About the application

Application number: 2023/91649	
What is the application for?:	Demolition and rebuild boundary wall
Address of the site or building:	11, Wood Street, Skelmanthorpe, Huddersfield, HD8 9BN
Postcode:	HD8 9AS

Title: **Retaining Wall – Construction Method
Plan**

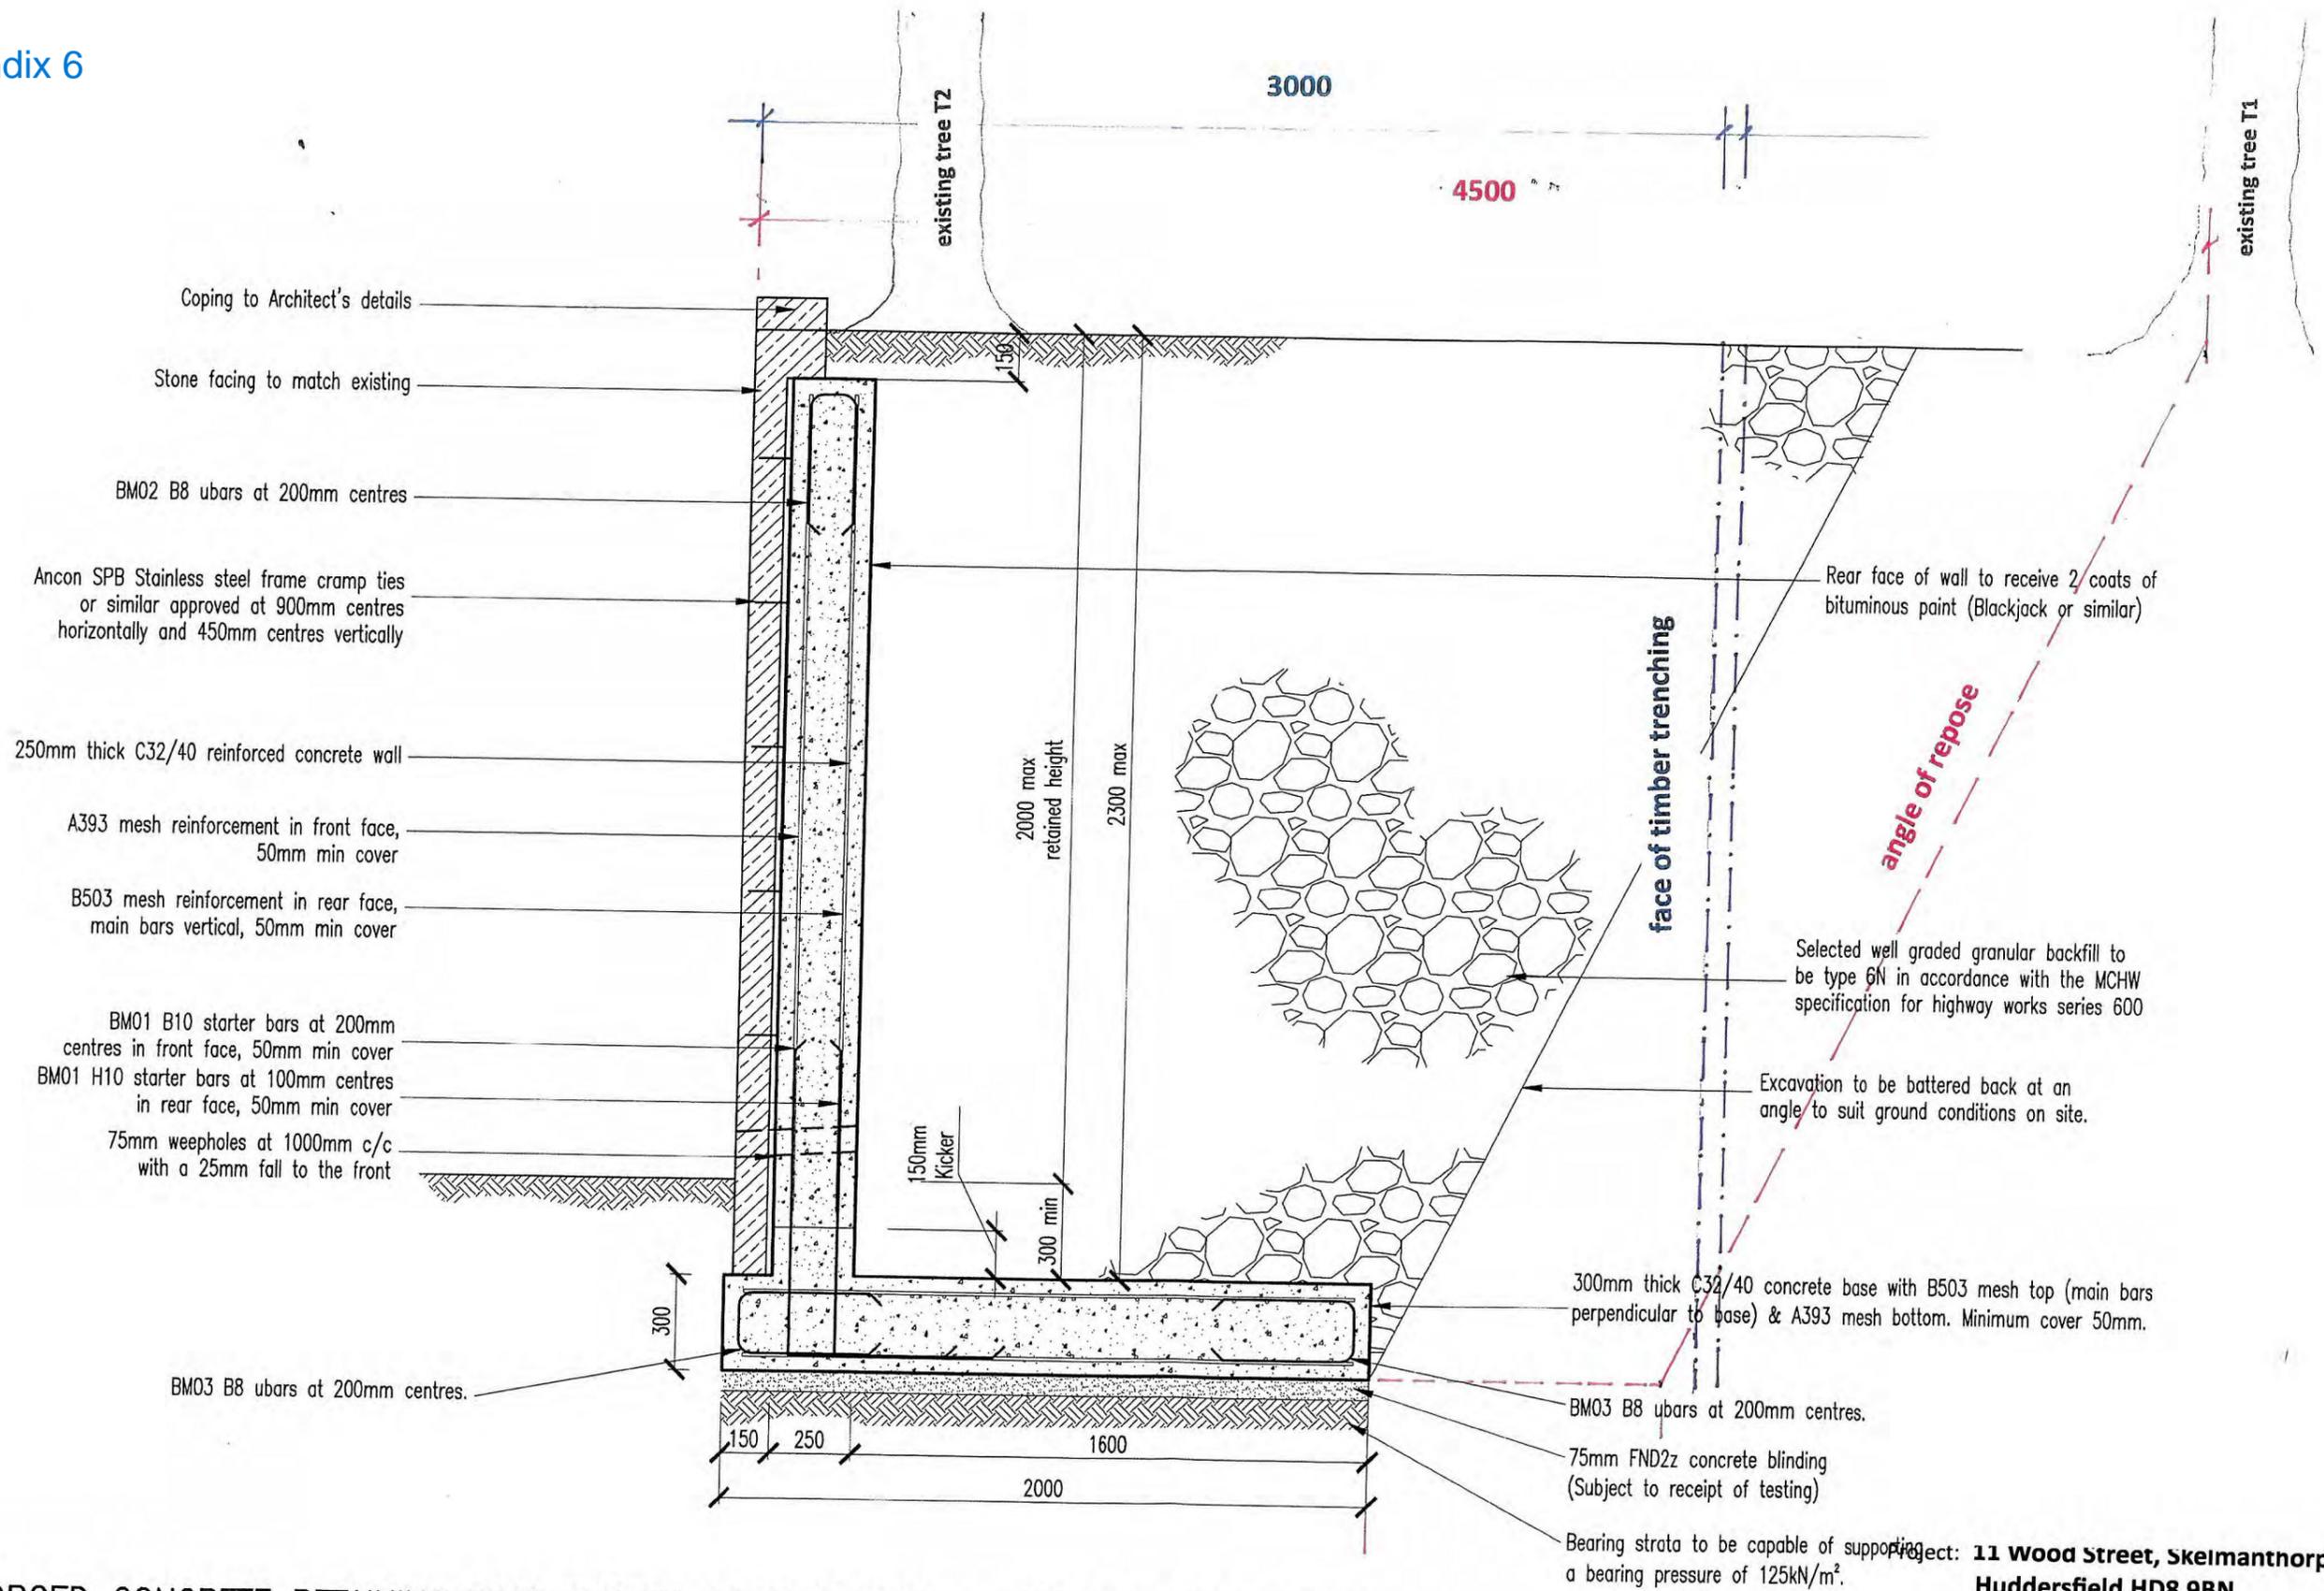
Type of comment: An objection	
Do you wish your comments to be published on the website anonymously?	Yes
<p>We strongly object to this application as we feel the loss of the trees would completely alter the appearance of Wood street. Although only 2 trees are shown on the plans there are at least 5 mature trees which would be affected and most, if not all, of these are subject to a TPO. In the fight to combat climate change, they are an asset to the environment and wildlife and it seems likely all will be affected by the plans.</p> <p>We would also question whether the wall is part of the applicant's property. Both it and the road have been maintained by Kirklees (and its predecessors) for far longer than the property at no. 11 has existed. One would suppose, therefore that it has been adopted by the local authority and that the applicant's property extends to but does not include the wall.</p>
